# KITITAS COUNTY

### MEMORANDUM

**TO:** All Staff  
**FROM:** Public Works Plan Review Team  
**DATE:** September 24, 2025  
**SUBJECT:** SPF-25-00005 Sedgwick

SEDGWICK SHORT PLAT

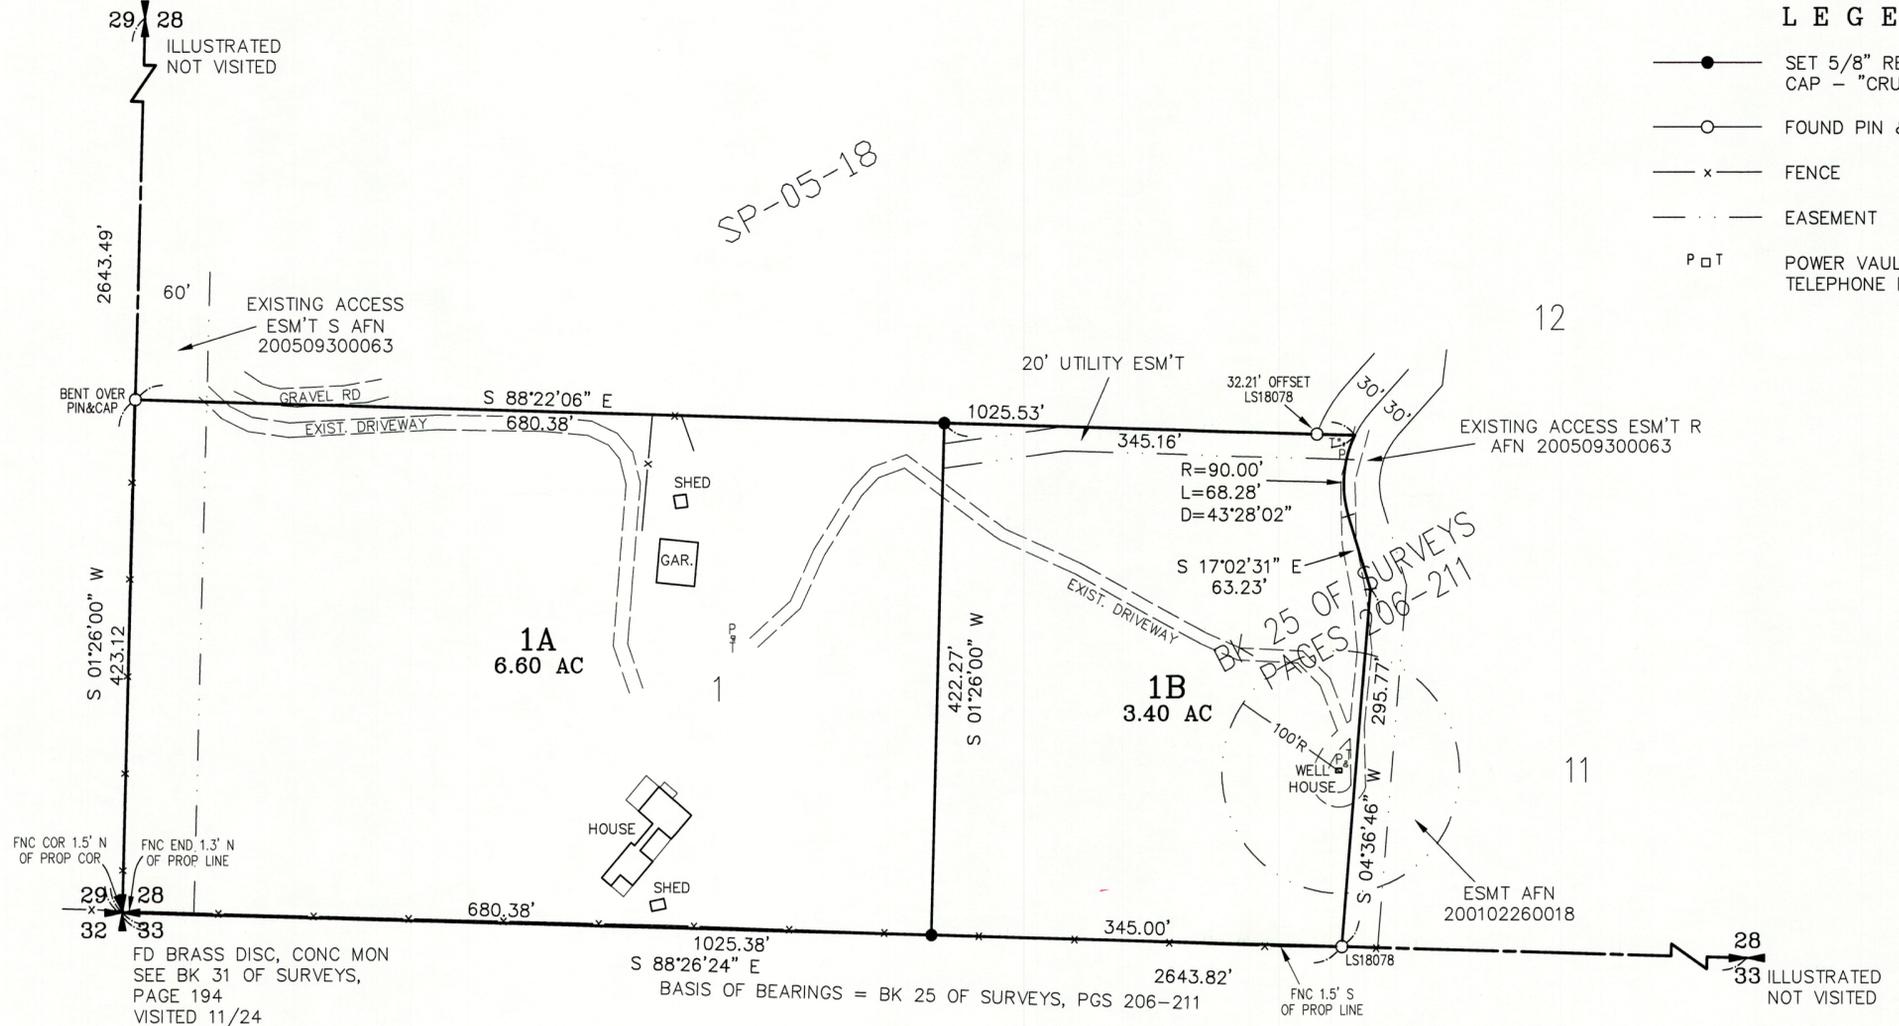
| <b>SURVEY</b>                     | <p>1. Label Fir Tree Drive and Mountain Creek Drive together with ownership (private) and surfacing.</p> <p>2. Show the westerly extent of Easement R through Parcel 1B, or provide proof this was vacated.</p> <p>3. Include detail about the 20' utility easement at the North line of Lot 1B. If existing, please include a document reference. If herein dedicated, please note. If the easement is being created, it must be retracable.</p> <p>4. Per aerial imagery, there appears to be a structure near the NW corner of parcel 1B. Please confirm this has been removed or is non-permanent in nature. If the structure still exists, please show that it meets necessary setbacks. (JT)</p> |
